From: [Rory Toomey](#)
To: [Phillip Rossington](#); [Georgia McKenzie](#)
Cc: [Troy Uleman](#); [Andrew Harvey](#); [Zoe Gleeson](#); [Vijay Prabhu](#); [Guy Pinkerton](#)
Subject: RE: Alexandria Health Centre - Design Integrity Panel Endorsement
Date: Friday, 7 June 2024 10:35:44 AM
Attachments: [image002.png](#)
[image003.png](#)
[image004.png](#)
[image005.png](#)
[image006.png](#)

RE: Alexandria Health Centre DIP Review RTS

Drawing Title
GROUND FLOOR MEZZANINE GENERAL ARRANGEMENT PLAN
Drawing Status
STAGE 2 SSDA

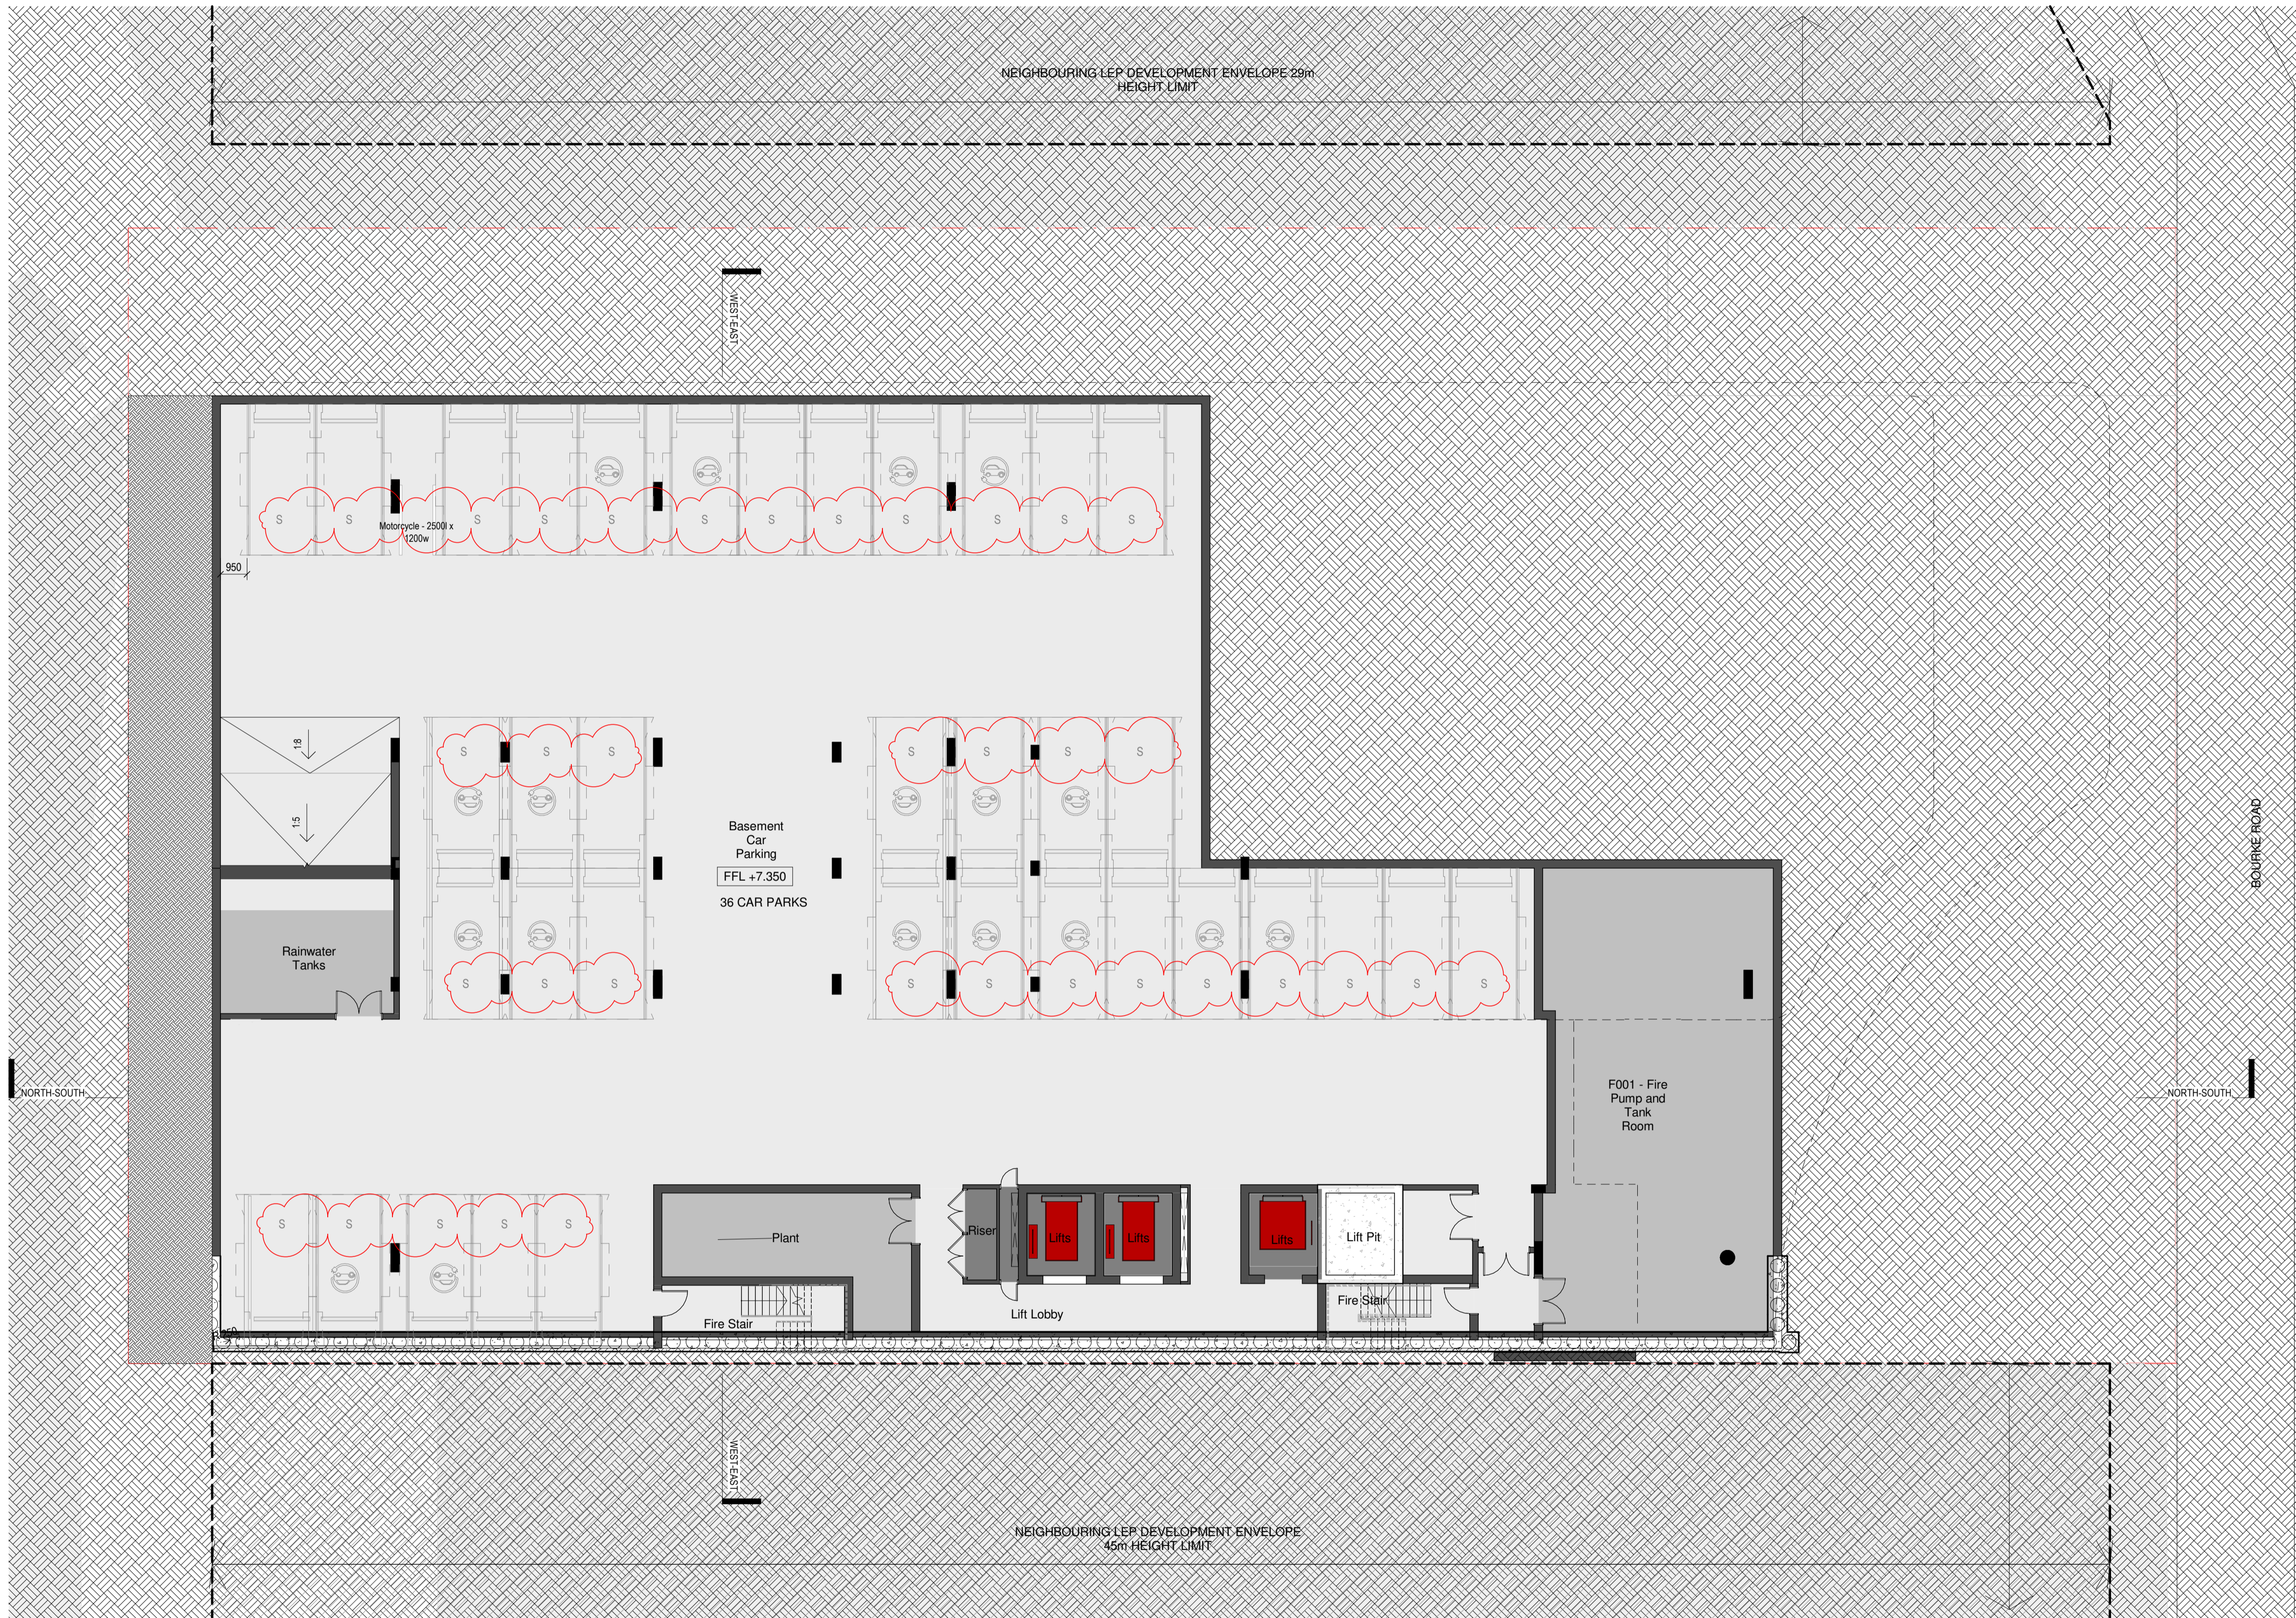
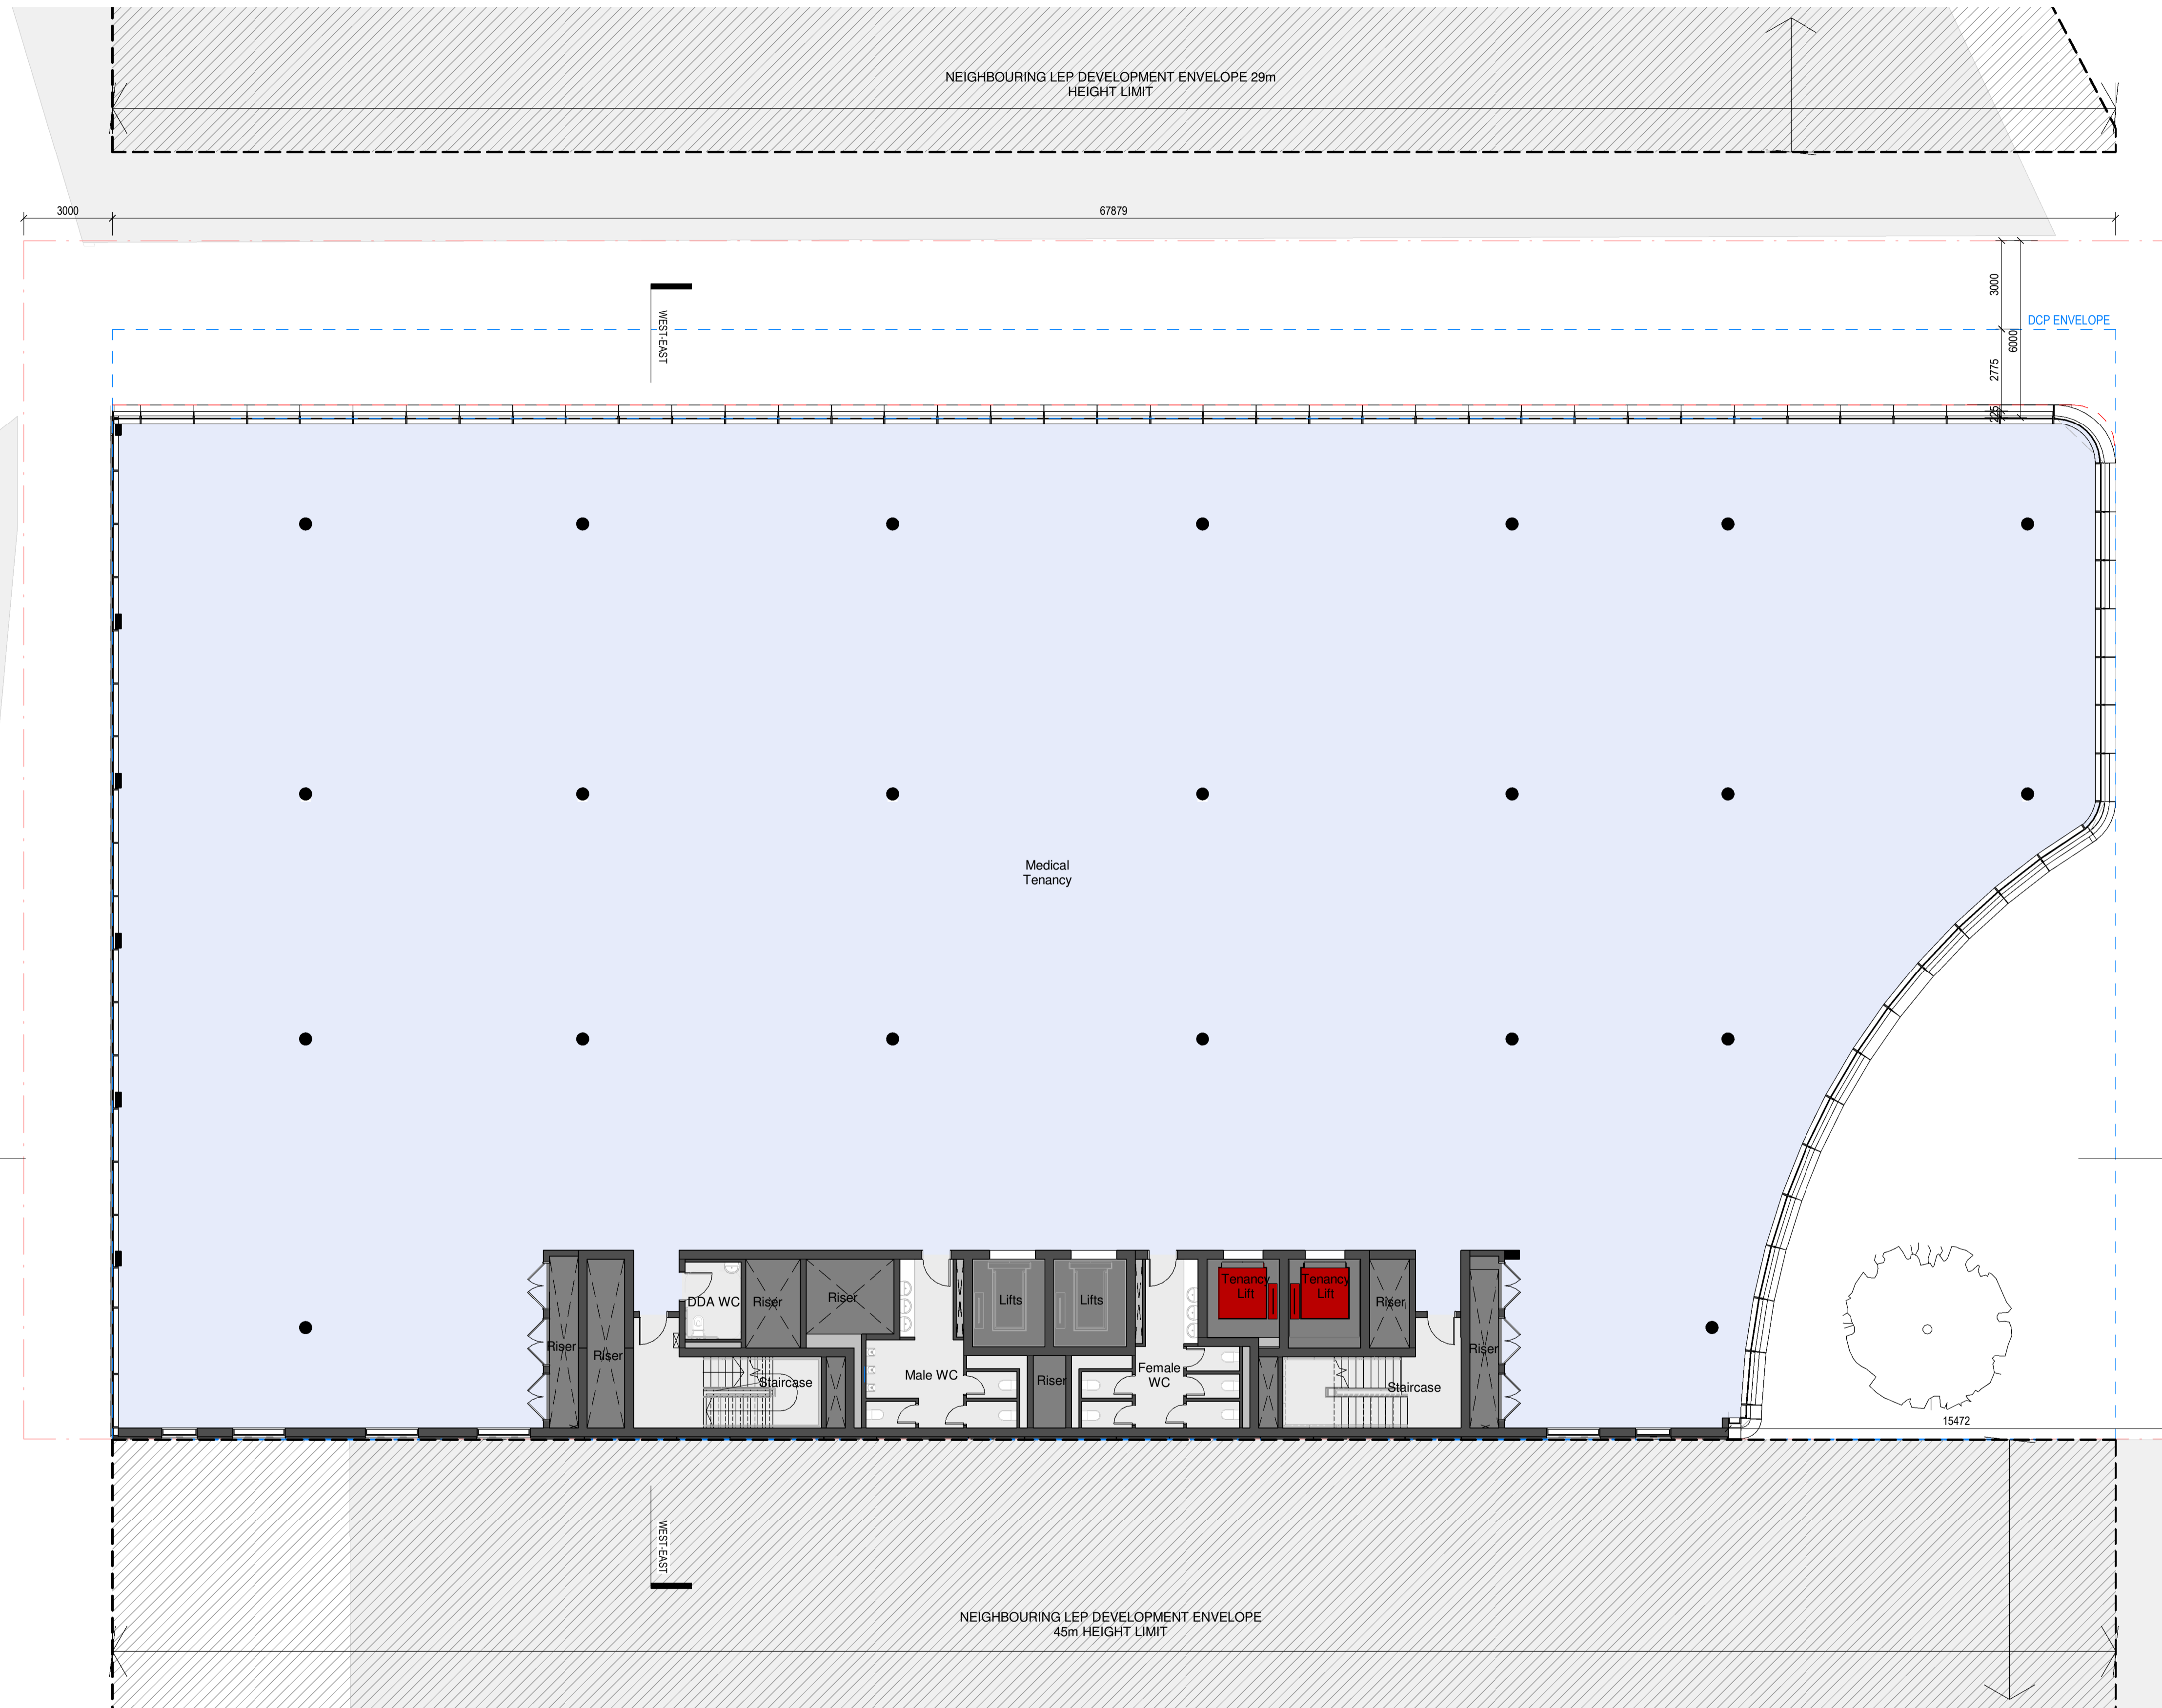
- Number and allocation of parking spaces
- Function, location and treatment of grease arrestor
- Legibility, safety and wayfinding for patient drop off space
